KIRKLEES METROPOLITAN COUNCIL INVESTMENT & REGENERATION SERVICE

DELEGATED DECISION TO DETERMINE APPLICATIONS FOR CONSENT, AGREEMENT OR APPROVAL REQUIRED BY CONDITION

Reference No:	2026/44/90240/W
Site Address:	Huddersfield Bus Station, Upperhead Row, Huddersfield, HD1 2JN
Description:	Discharge of details reserved by conditions 12 (phase 1 surface water management), 17 (external plant or machinery), 31 (phase 1 bus disruption plan) and 32 (phase 1 foundation proximity to railway) on previous permission 2025/91604 for Variation condition 2 (plans) on previous permission 2024/92302 for refurbishment comprising (phase 1): facade improvements including Henry Street entrance; replacement shop fronts; alterations to external bus apron; extension and alterations to existing barrier within the bus alighting lane adjacent to Henry Street; (phase 2): new entrance canopy; public realm improvements; cycle hub; facade improvements including replacement shop fronts
Recommending Officer:	Liz Chippendale

DECISION – Discharge of Condition – Approve

Section 4-4 (Through Bus Bay 1)  
 Scale: 1:100

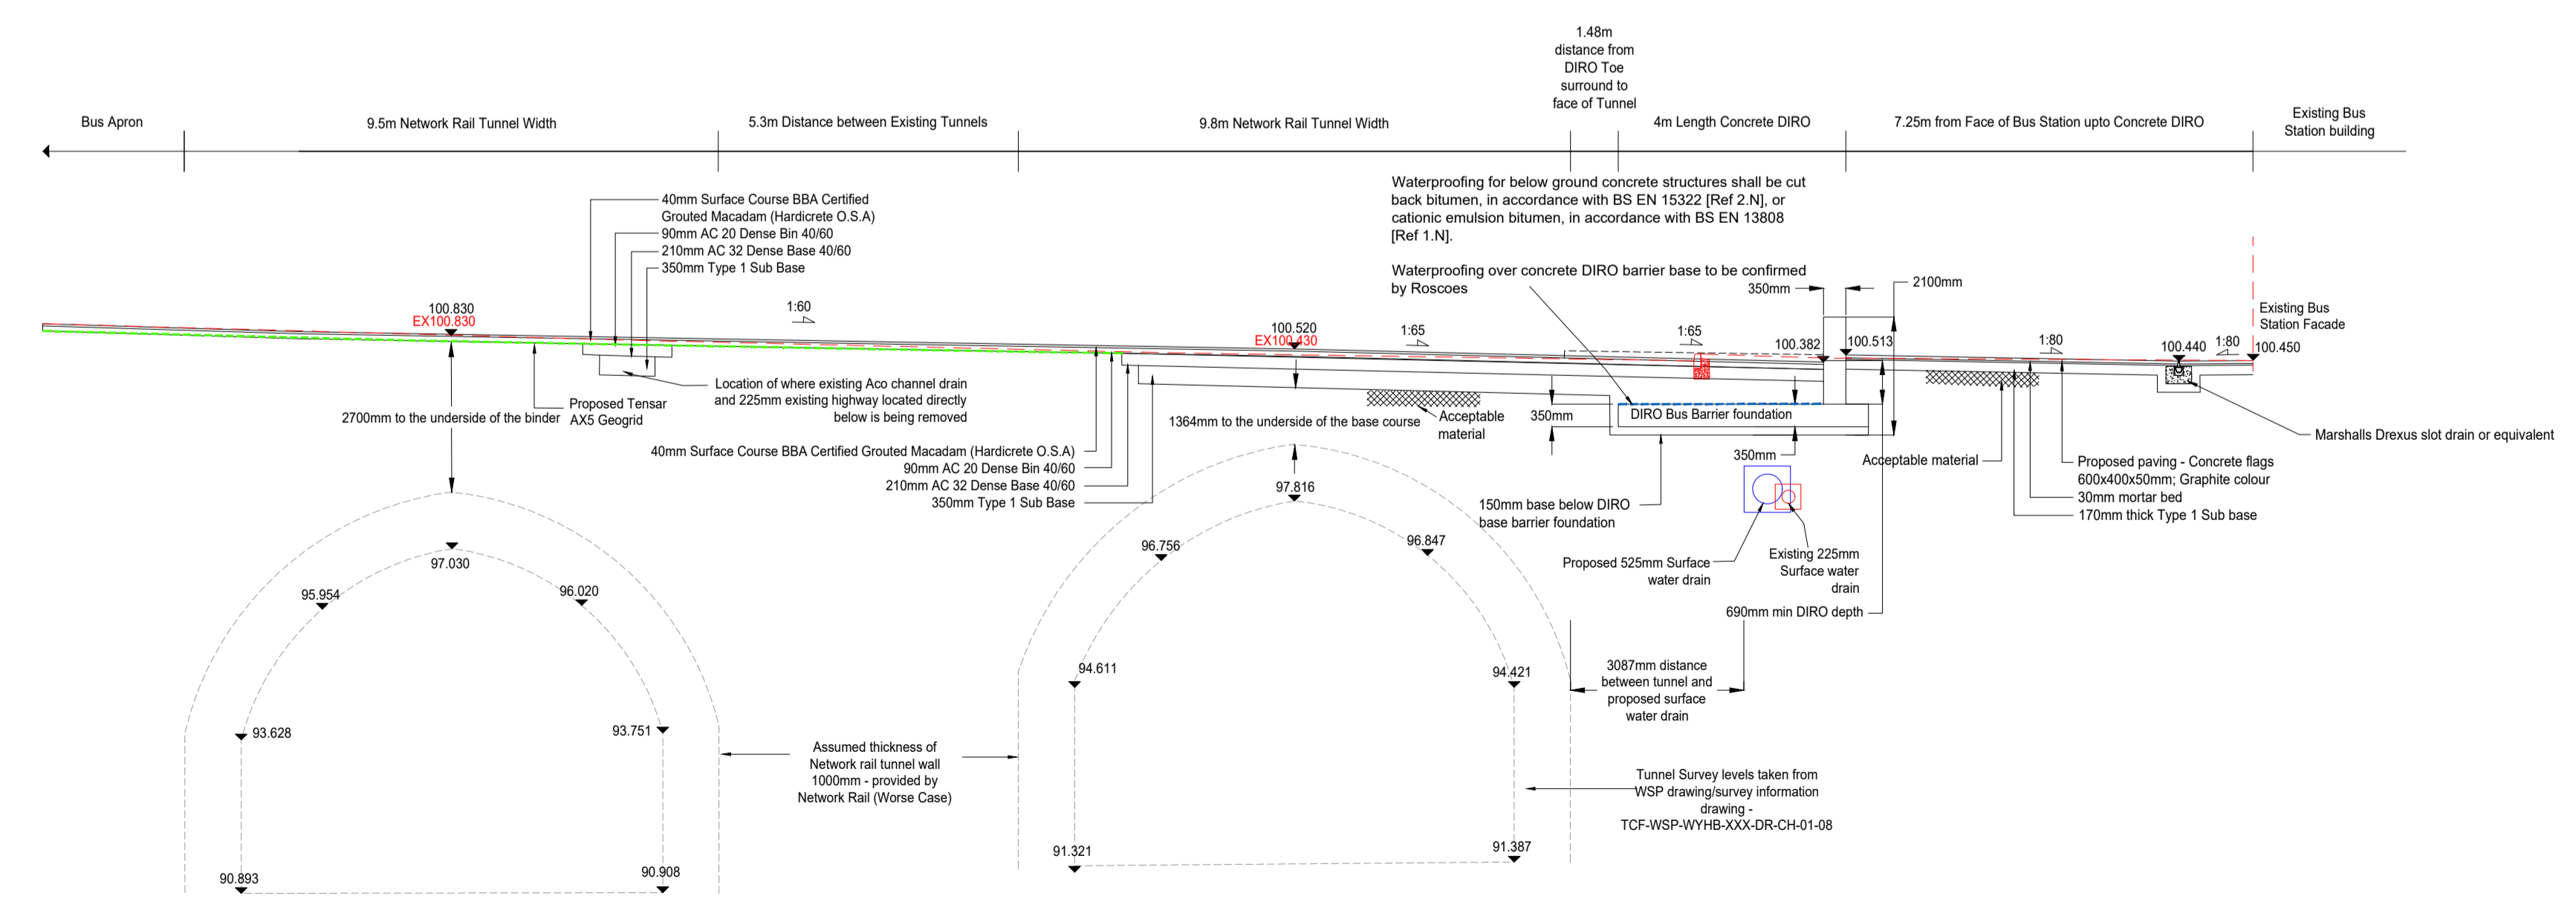
While we acknowledge that the proposed foundations, as detailed under condition 32, fall outside the tunnel's support zone, we would nonetheless recommend coordination with our Asset Protection Team. This engagement would ensure appropriate oversight and provide assurance that the works will not adversely affect the operational railway or associated infrastructure.

Officers concur with the comments and assessment made by Network Rail in that the details provided are sufficient for the requirements of condition 32 provided that the development is completed in accordance with the approved details.

Network Rail advise that the applicant coordinates with the Network Rail Asset Protection Team to ensure the appropriate oversight and provide assurance that the works will not adversely affect the operational railway or associated infrastructure.
